Permit Number: BCOM2603-0008

Description: **Auto Retail Shop & Unpermitted 12x16 Prefab Storage Building**

LIST OF REVIEWS

BLDG KEY PLAN
1:50

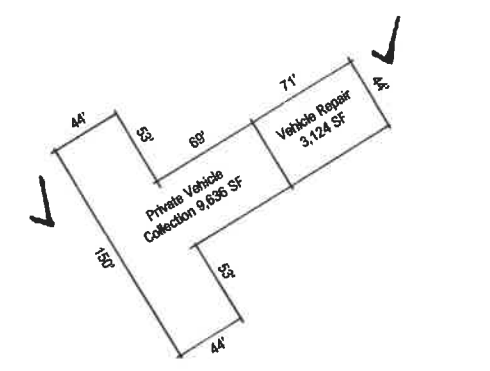
SENT DATE	RETURNED DATE	DUE DATE	TYPE	CONTACT	STATUS	REMARKS
Review Group: 1ST PLAN REVIEW						
3/27/2026		4/13/2026	FIRE MARSHAL	Fire Bucket		
Notes:						
Review Group: AUTO						
3/27/2026	3/27/2026		COMMERCIAL INTAKE	CP Bucket	APPROVED	SITE2208-0002
Notes:						
3/27/2026	4/1/2026	4/13/2026	COMMERCIAL BUILDING REVIEW	Brad Sutton	DISAPPROVED	
Notes: Need a plan drawn to scale. Cannot count garage doors as exits. Plan must have all rooms in the building shown						
4/1/2026			COMMERCIAL BUILDING REVIEW	Building Bucket		
Notes:
